**Re: ADS Office Building Conceptual Grading Plan**  
**Engineer's Stamp dated 5-4-07 (C13/D25E)**

**Re: ADS Office Building Conceptual Grading Plan Engineer's Stamp dated 05/04/2007  
(C13/D25E)**

# CITY OF ALBUQUERQUE

**Re: ADS Office Building Conceptual Grading Plan**  
**Engineer's Stamp dated 3-13-07 (C13/D25E)**

CONCEPTUAL GRADING PLAN

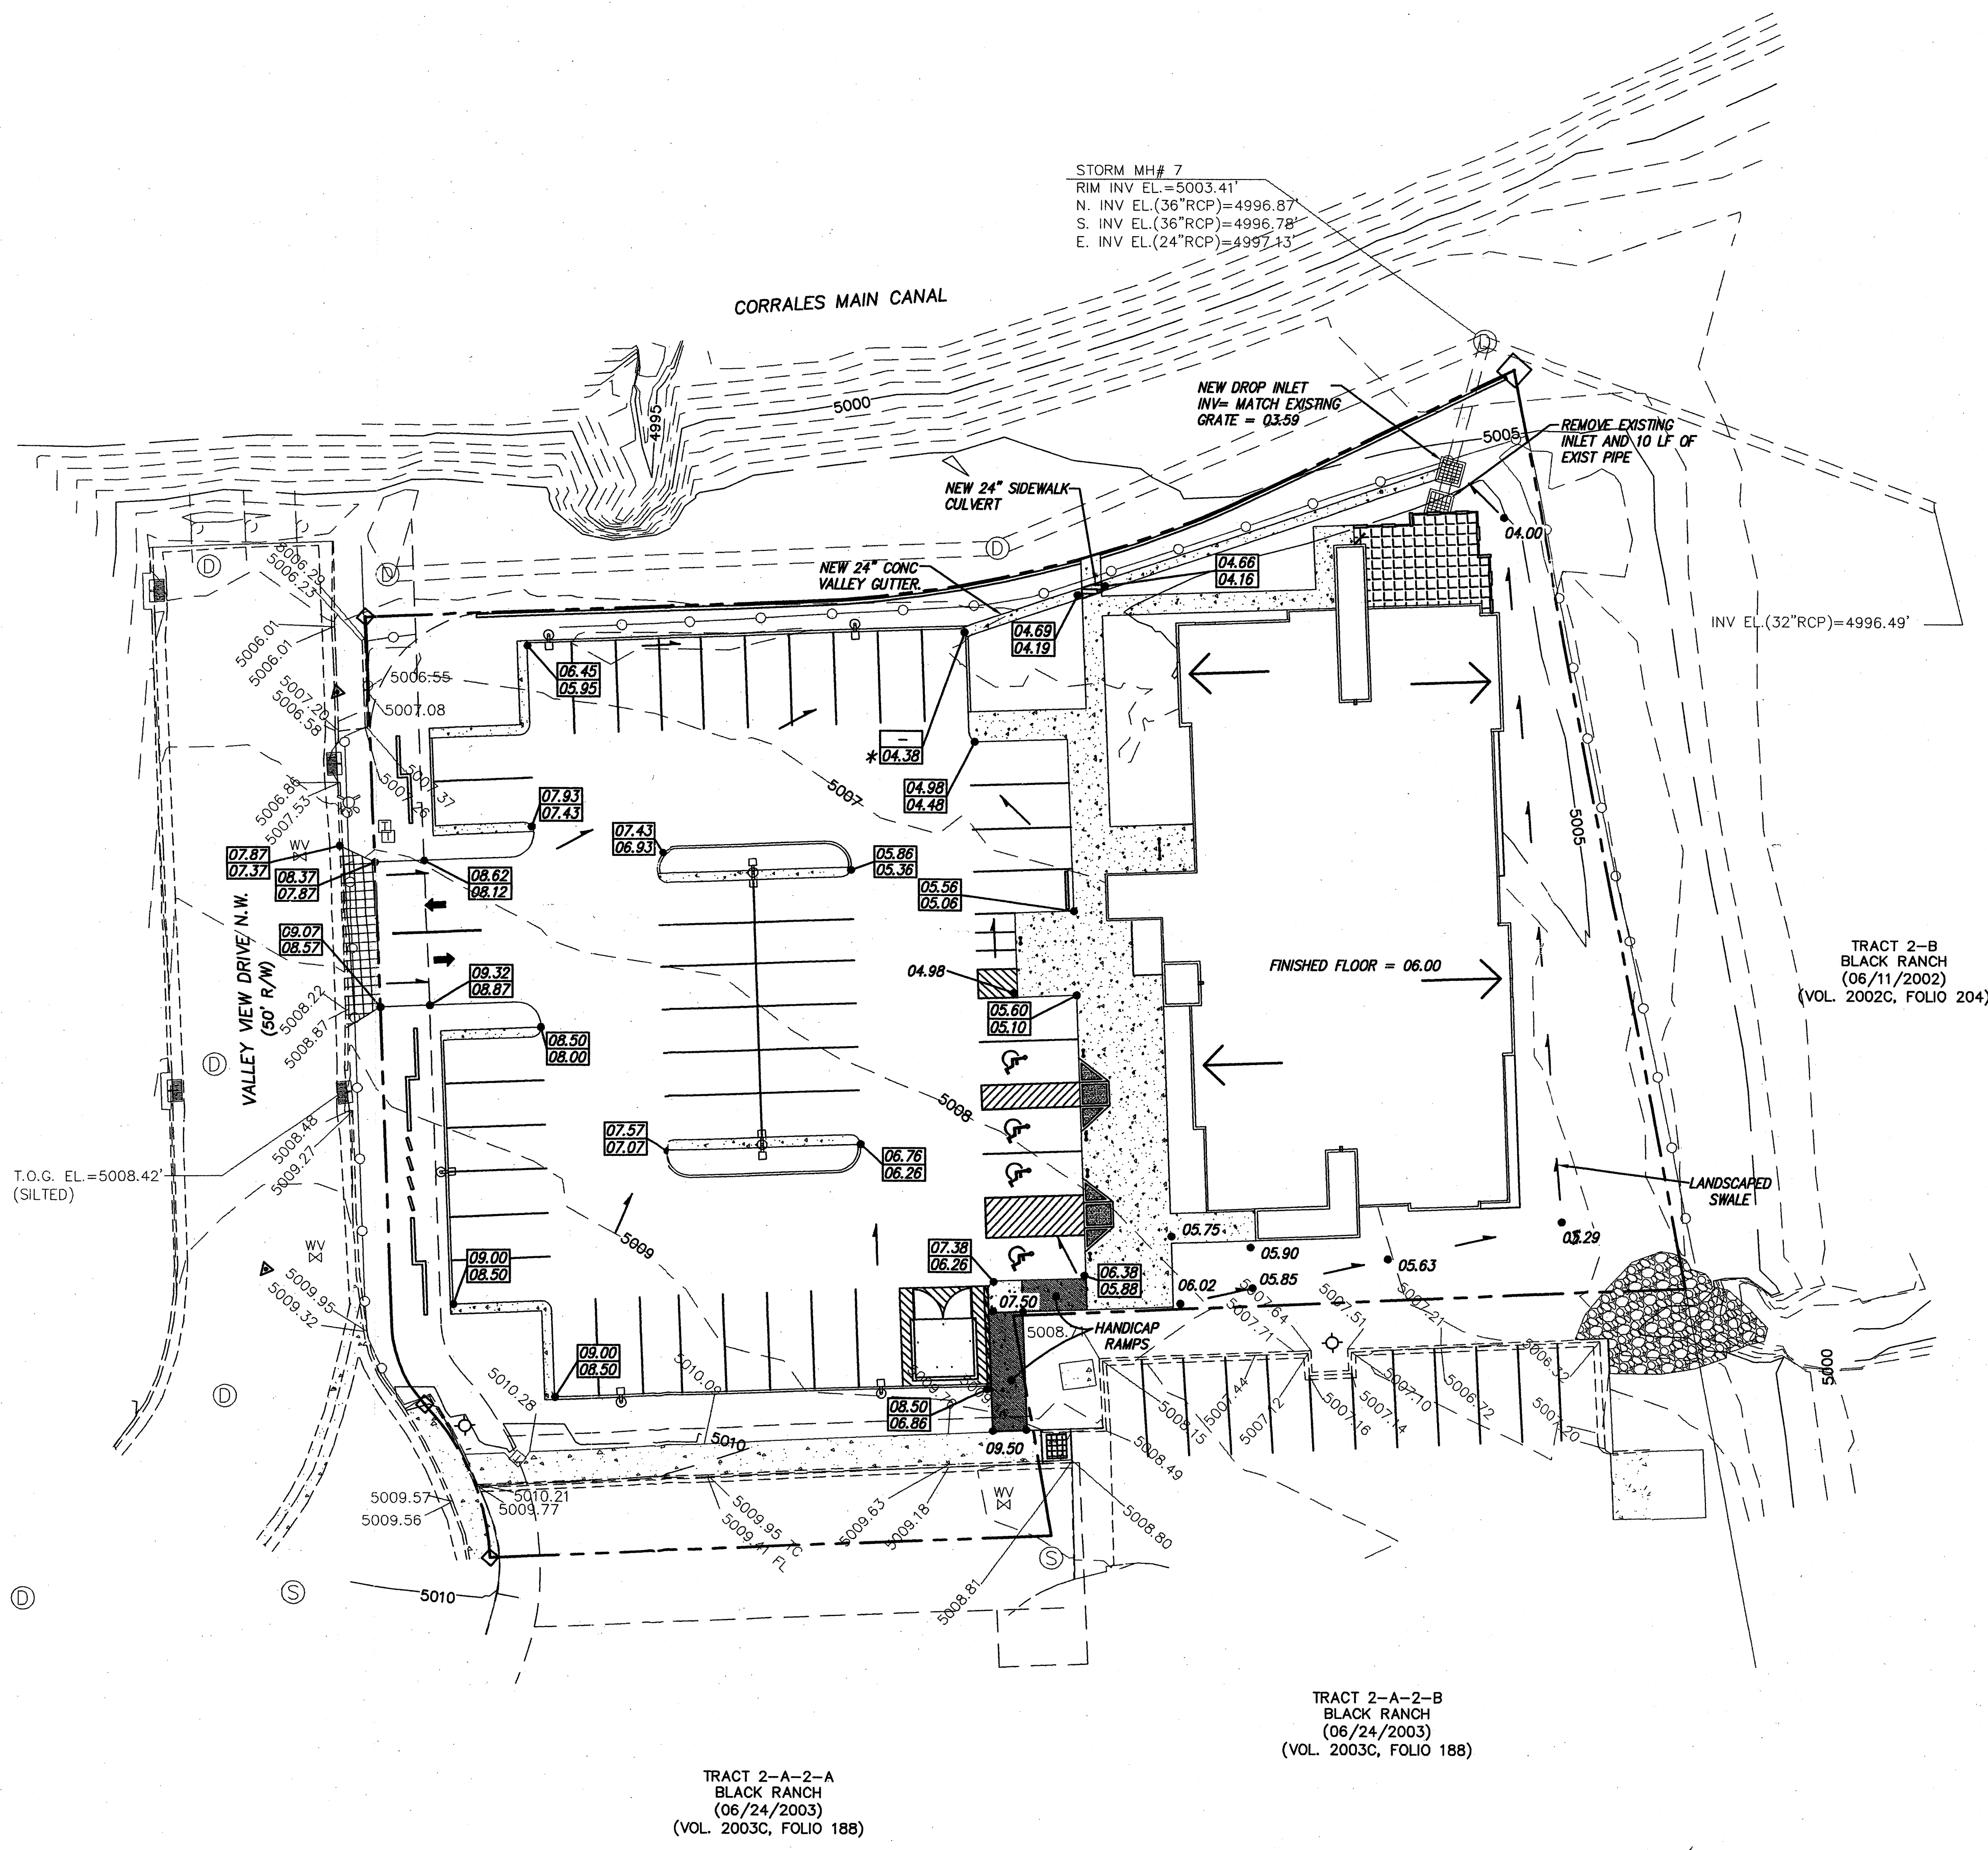
- Please quantify both onsite and offsite runoff.
- Provide design calculations for the landscaped swale.

- Your plan shows a basin draining directly to the AMAFCA pond on Tract 2B. This is contrary to the master plan (which should be referenced on this plan) so written AMAFCA concurrence will be required.

- Runoff calculations and land treatment percentages should be provided for each basin.
- This plan should not be conceptual for a Building Permit. It needs to be constructible and certifiable and all applicable build notes (inverts, details, standard references) should be added.

- What facility is referenced in the covenant recorded in 2003? Are you removing it? Please elaborate.
- Provide details about the swale proposed. A swale at 4.6% will be erosive and erosion control measures should be noted on the plan.

- There is an inlet in your driveway. Are you intending to relocate it? If so, this must be done by City Work Order and should be annotated as such on the plan.

- No spot elevations were given in Valley View and it is difficult to determine if an adequate waterblock is provided.
- Is a retaining wall needed along the AMAFCA access road?

- We have revised the grades on the plan so that the runoff is directed into the inlet in the SE corner of property instead of directing some it to the AMAFCA pond on Tract 2B. The AMAFCA master plan will be referenced with the BP plan.

- Runoff calculations along with the land usage percentages are attached. With this plan the site is one basin. With the building permit plan it will be split into two with specific flow rates identified.

- This submittal is only for approval of conceptual grading and drainage plan and not the building permit approval.
- The covenant for the temporary pond recorded in 2003 is planned to be released administratively in connection with the building permit G & D.

- The slope of the swale along the south side of the building is approximately 1% or less. This swale will also carry off-site flows from developments to the west of the site. A preliminary hydraulic analysis of this swale shows that it will have more than sufficient capacity to convey both on-site and off-site flows to the SE corner of the site. The landscaped surface of the swale may have to be modified so that it is not subject to erosion. We will be sending an e-mail to the architect to recommend the change.

- We have changed the location of the driveway so it will not affect the inlet on Valley View.
- We have added spot elevations on Valley View to show there is an adequate water block.

- We are matching the existing grade along the east property line so there is no need to have a retaining wall along the AMAFCA access road.
